DECISION DELEGATED TO HEAD OF PLANNING

Application No:	H14-0893-22	Applicant:	Anglia (UK) Ltd.
Proposal:	Details of scheme to deal with external materials, design & position of external meter boxes, gas flues & soil vent pipes, existing & proposed site levels & proposed floor levels and means of foul & surface water disposal (Conditions 4, 5, 7 & 9 of H14-0295-22)		
Location:	The Anglia Business Centre Mill Green Road Pinchbeck		
Terminal Date:	18th December 2023

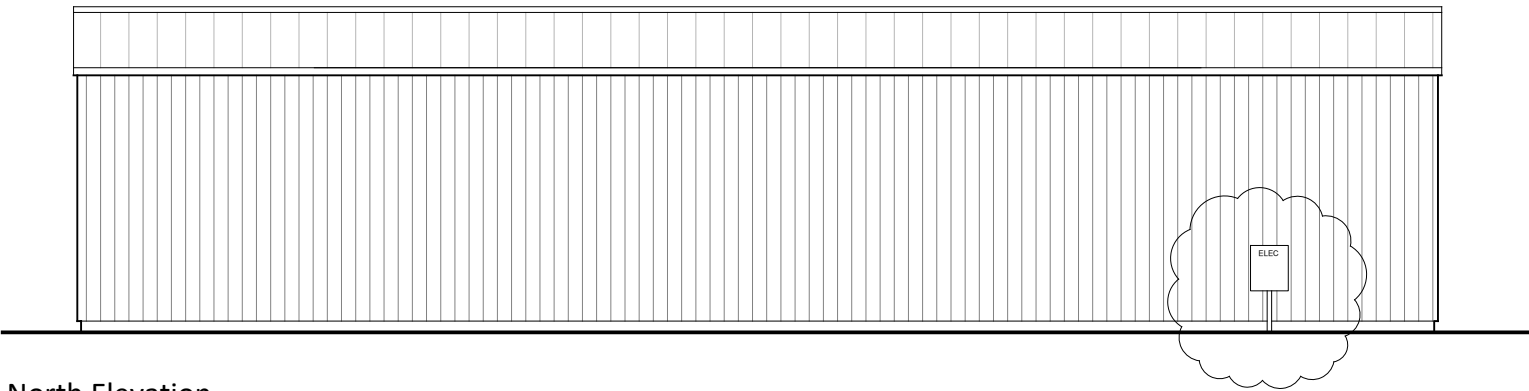
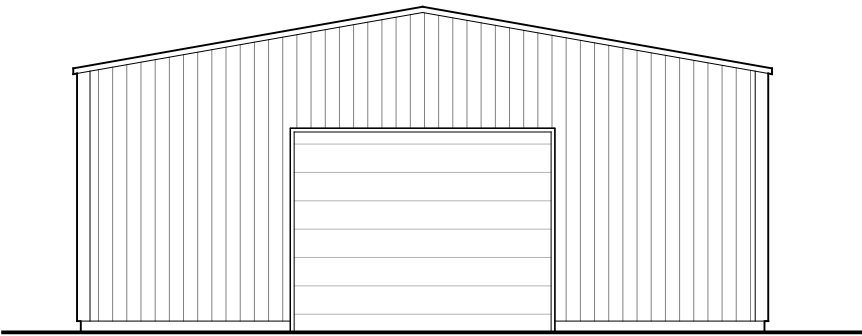
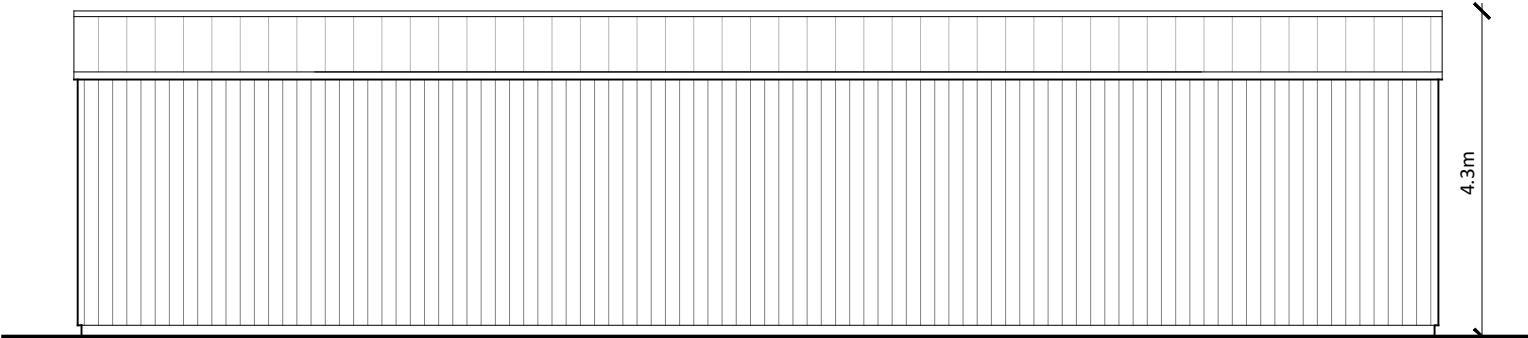
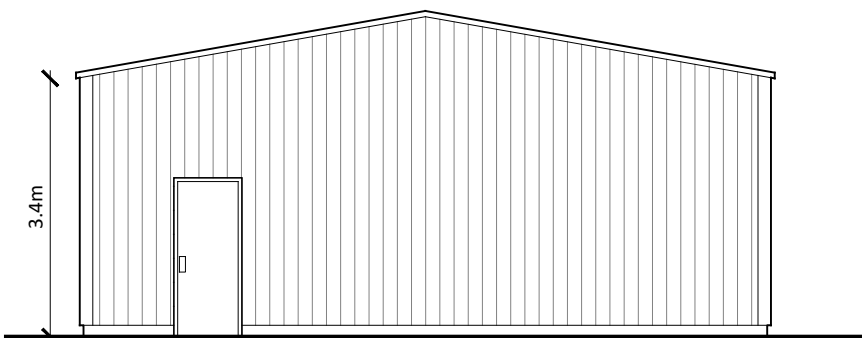
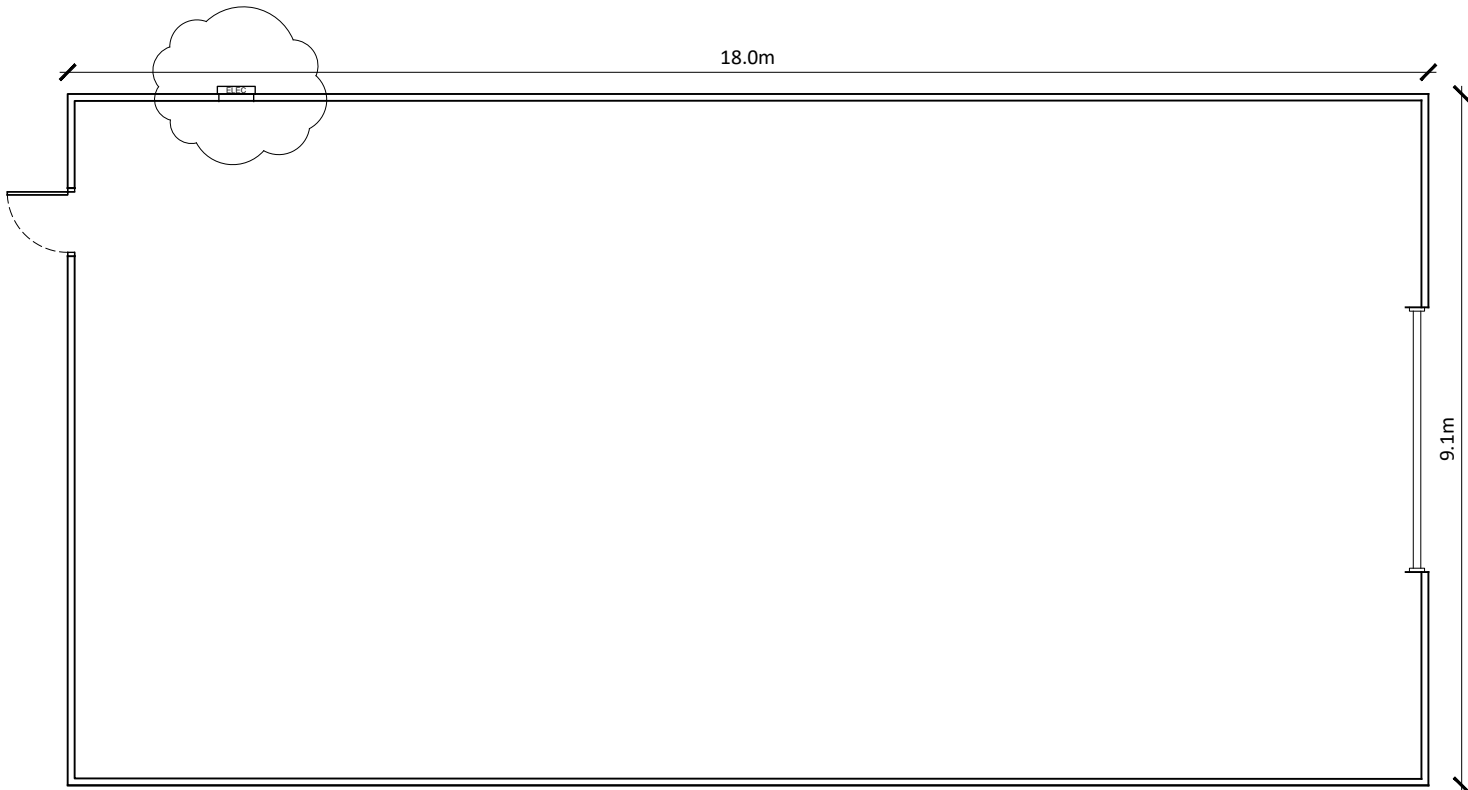
The proposed materials for the storage building are dark green Kingspan Trapezoidal Profile Cladding - vertical panels (or similar), with an Aluminium Polyester Powder Coated roller shutter door.

The proposed electricity meter box location is on the north facing frontage wall of the dwelling, but remains visually discrete and allows for easy access. For the storage building, the proposed electricity meter box location is on the north facing frontage wall of the dwelling, but remains visually discrete and allows for easy access.

The existing site levels around the storage building are between 3.05m AOD and 3.23m AOD. The proposed finished floor levels of the building will be set at 3.45m AOD, with the surrounding land unaltered. The storage building is to be 4.3 metres in height. As the storage building is sited to the north of the dwelling and the sun traverses the sky on a southerly trajectory from east to west, there will not be an overshadowing or overbearing impact on the property.

Proposed East Elevation

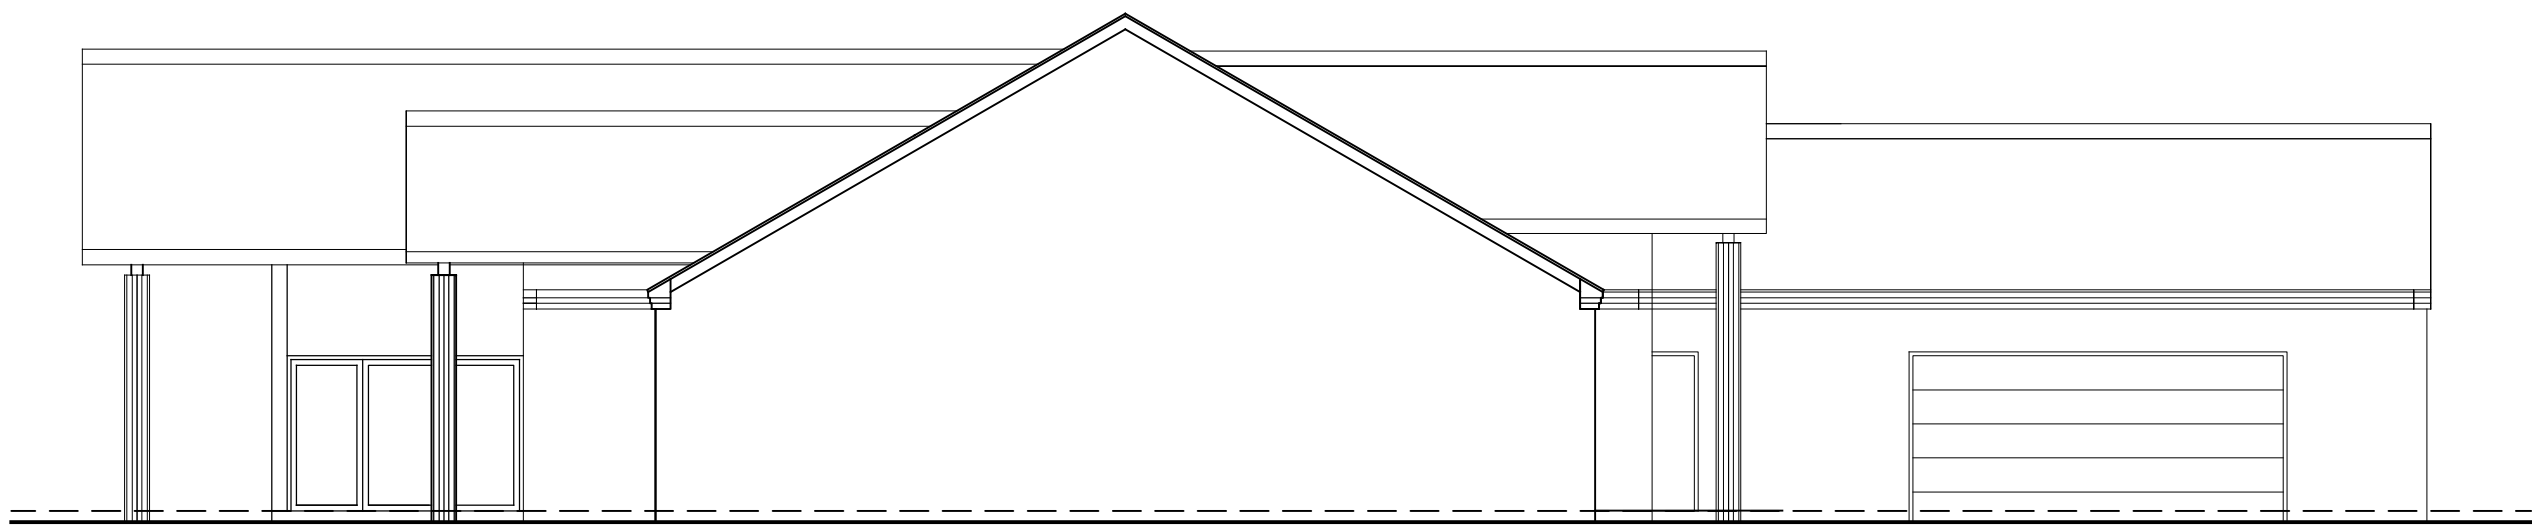
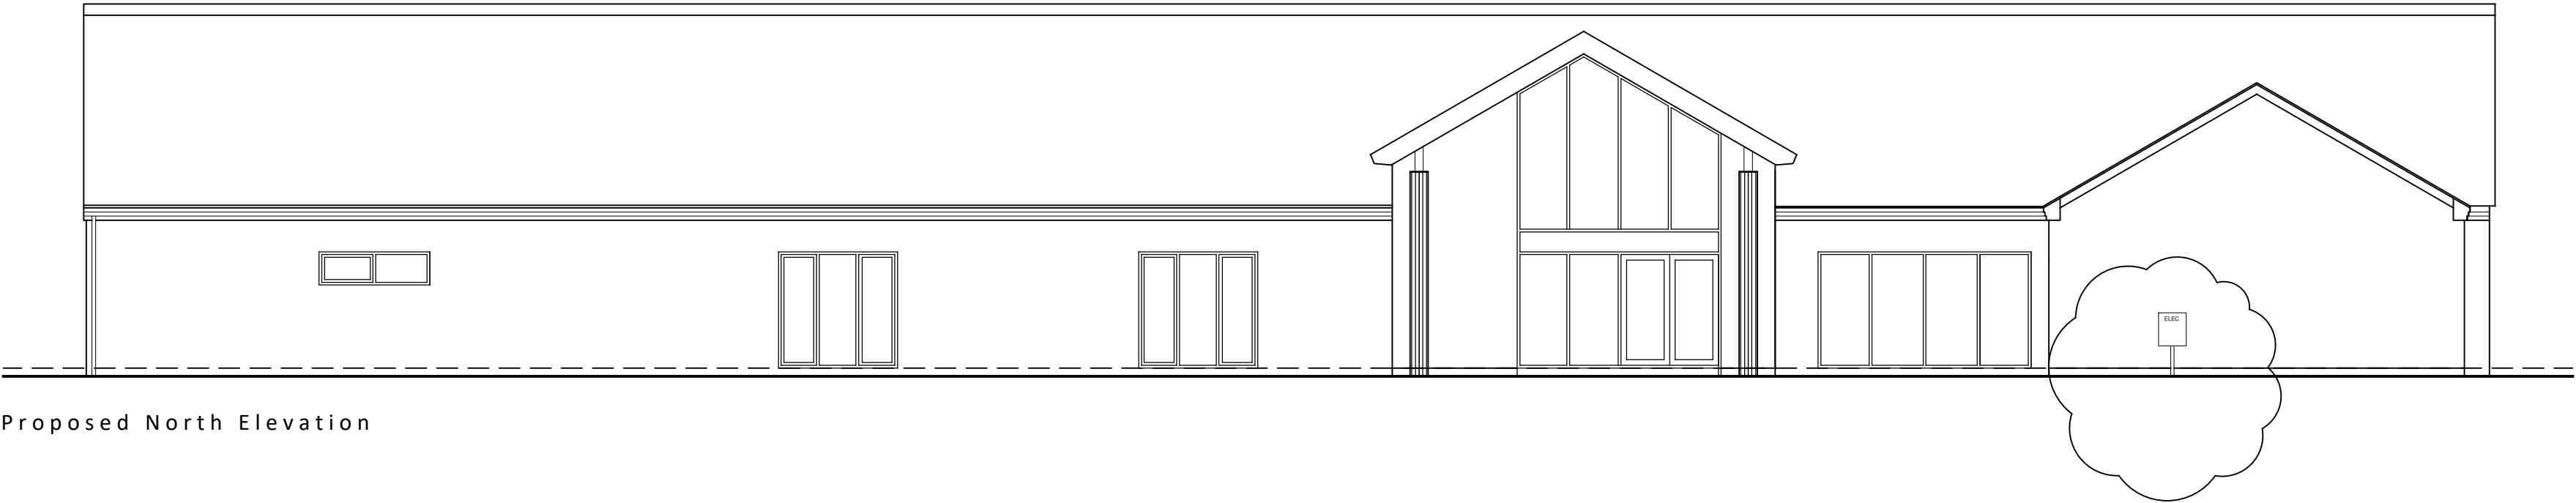
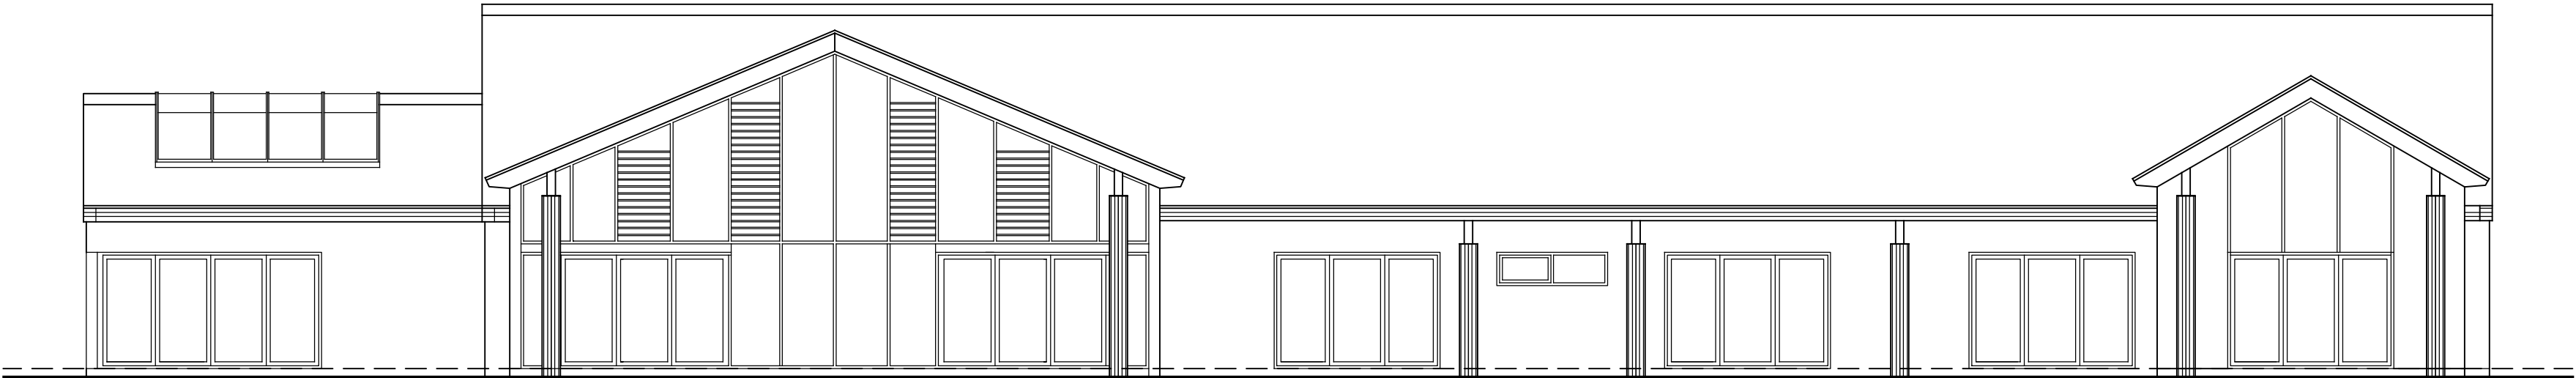
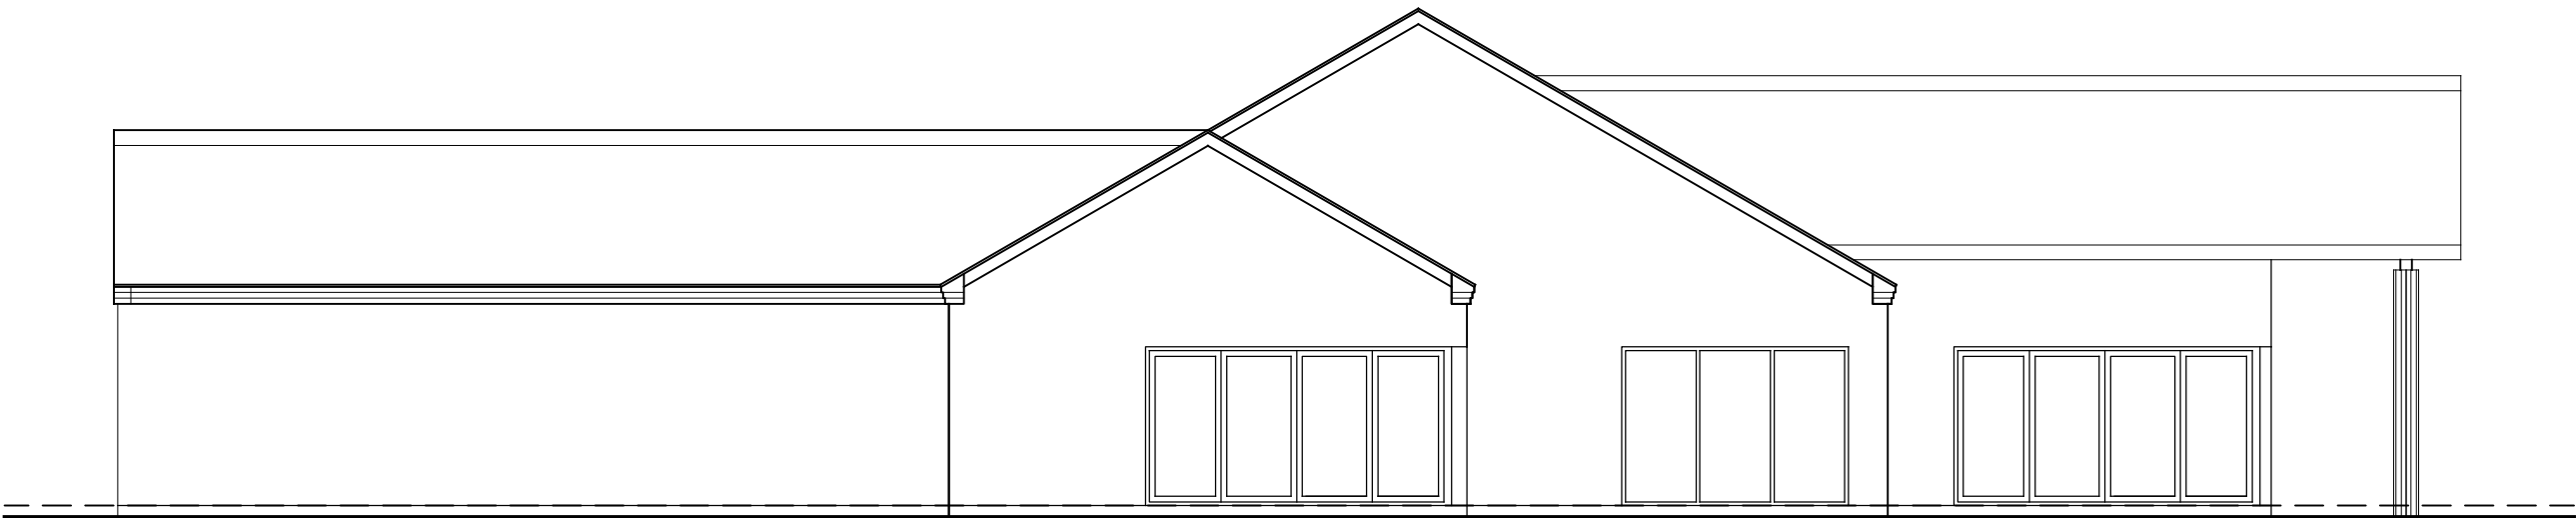
The proposed materials for the dwelling are Red, Multi-faced (Wienerberger Tabasco Red Multi or similar), with Clay pantiles (Marley Lincoln Clay profile - Rustic Red or similar. Windows and doors are to be anthracite grey coloured aluminium.
